From: Parish Clerk Billington and Langho Parish Council
<parishclerk@billingtonlanghopc.org>
Sent: 21 March 2024 14:53
To: Planning
Subject: 3/2024/0155

Further to consultation with all members of the parish council, the following strong objections and concerns have been raised.

Ground Floor Plan

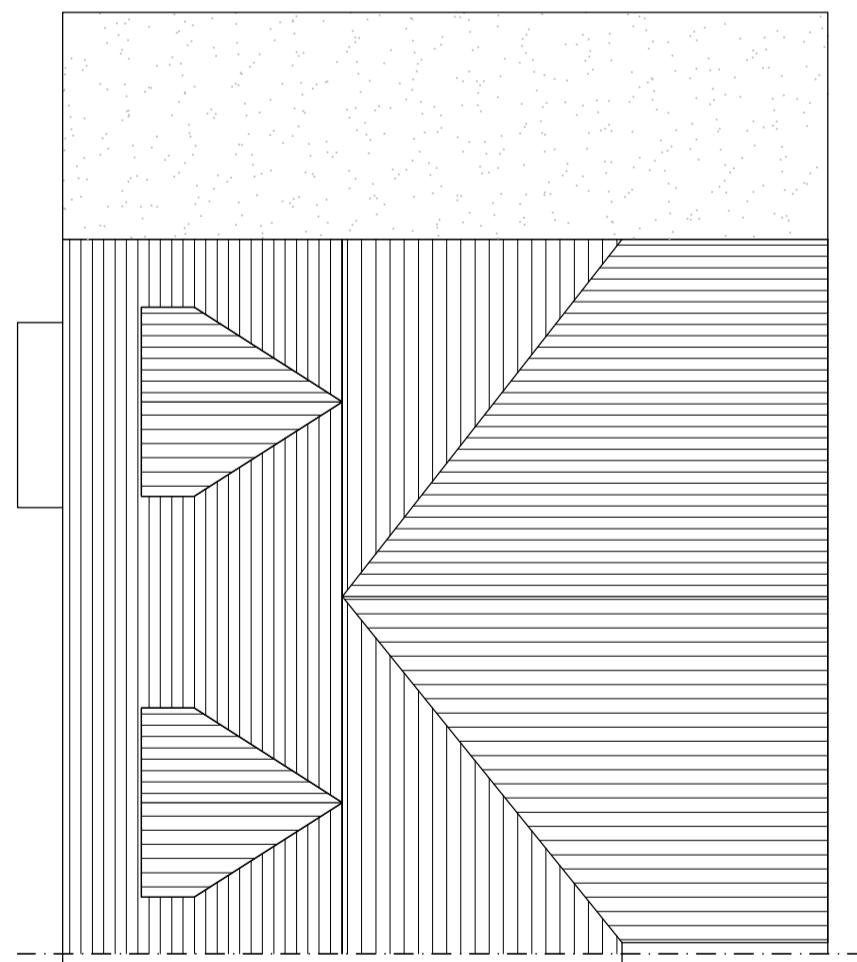
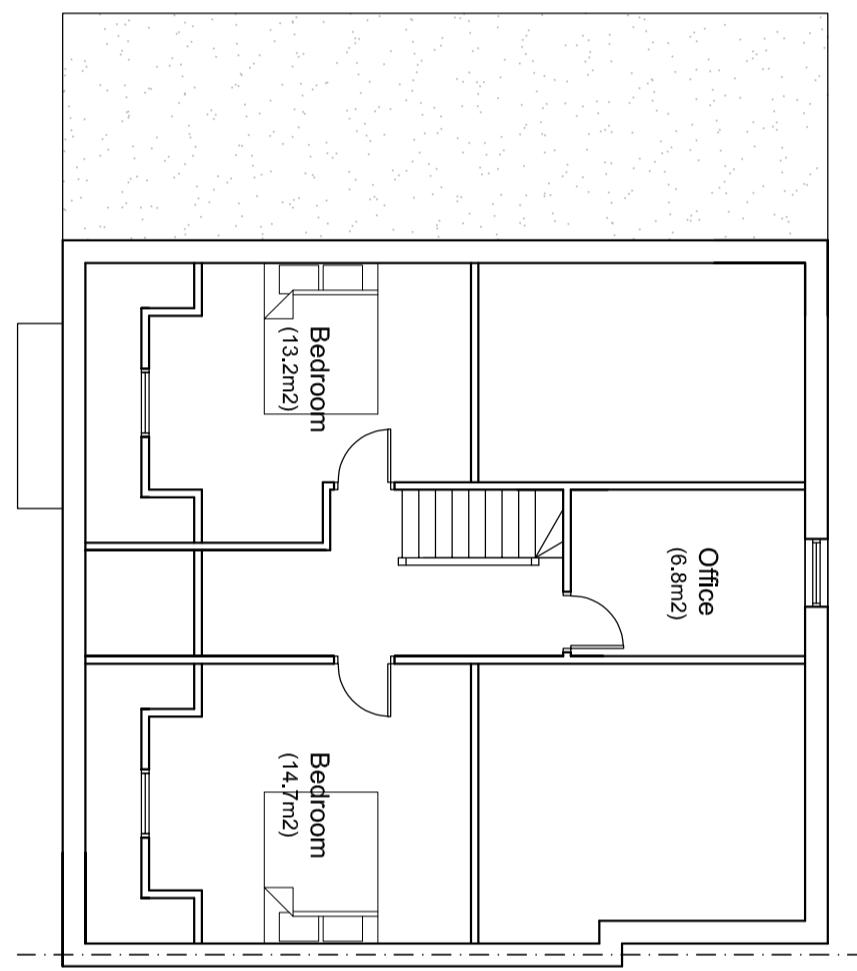
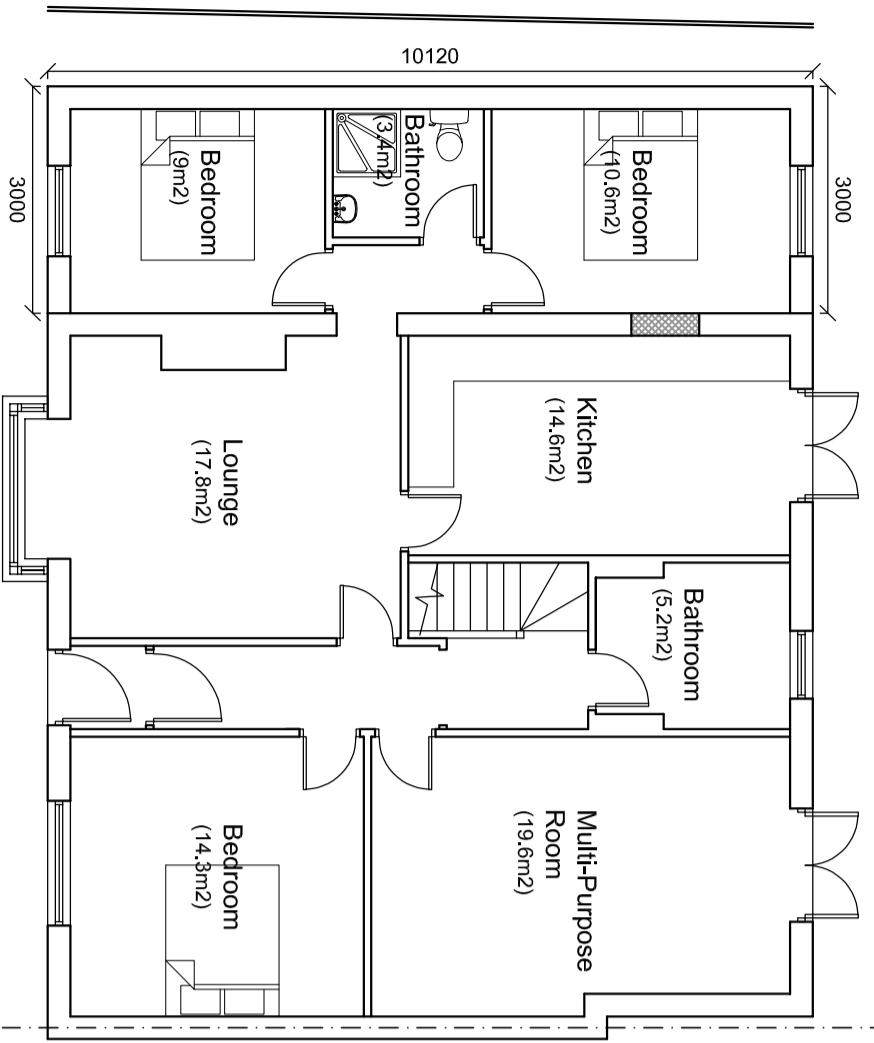
6. The plan shows 5 bedrooms in the semi-detached chalet bungalow care home on the two floors, but there are two rooms on the first floor that have no designated name attached. Potentially, if the permitted change of use was allowed, these rooms could also be turned into bedrooms, making an overly intensively used building with 7 bedrooms.

Front (North West) Elevation

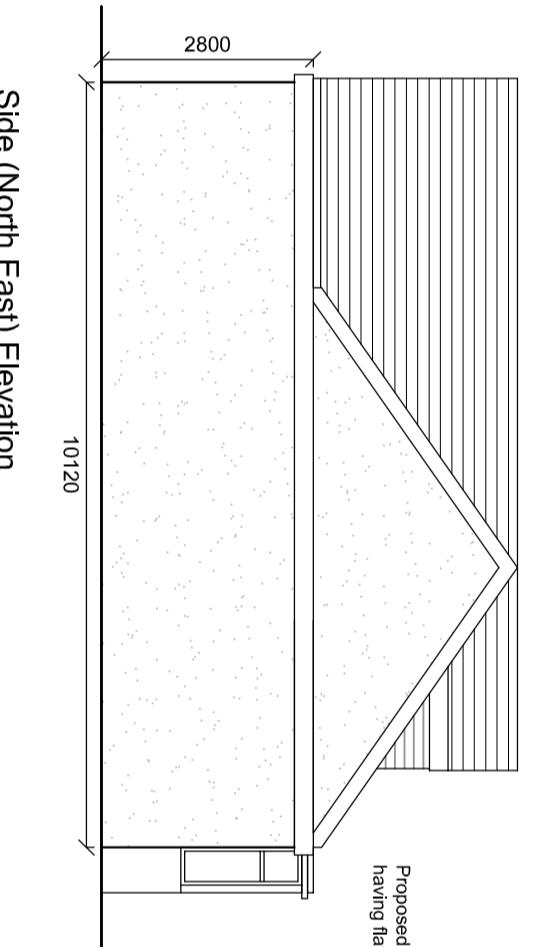
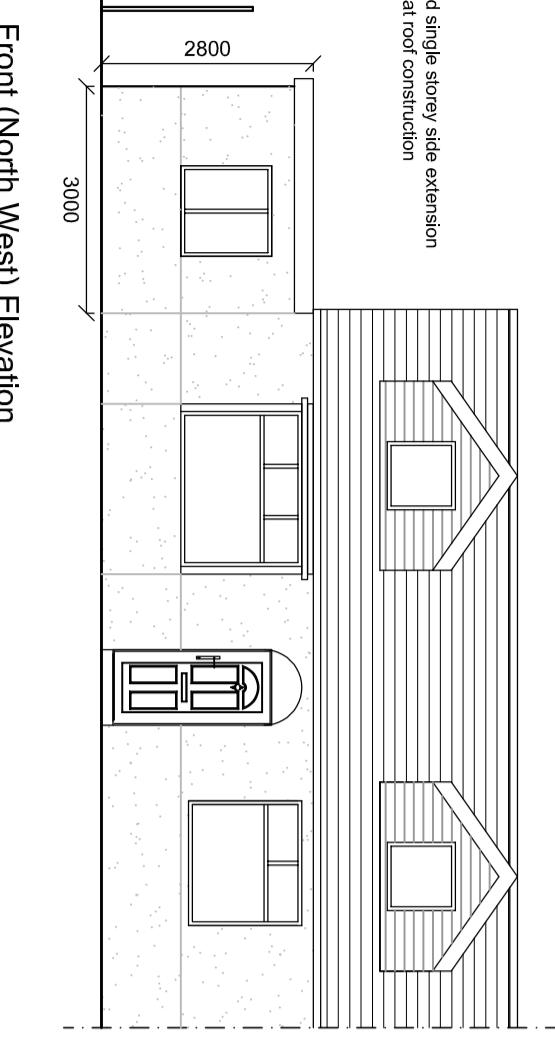
5. The application shows 3 car parking spaces in the front garden, but this is not much of an increase, because the existing garage has been demolished retrospectively to be replaced by one of two new bedrooms, the other being again a new extension with no permission. With there being a shift system of carers working at the bungalow, 3 car spaces will definitely be needed, though there should really be additional space to enable cars to enter the main Whalley Road in forward gear.
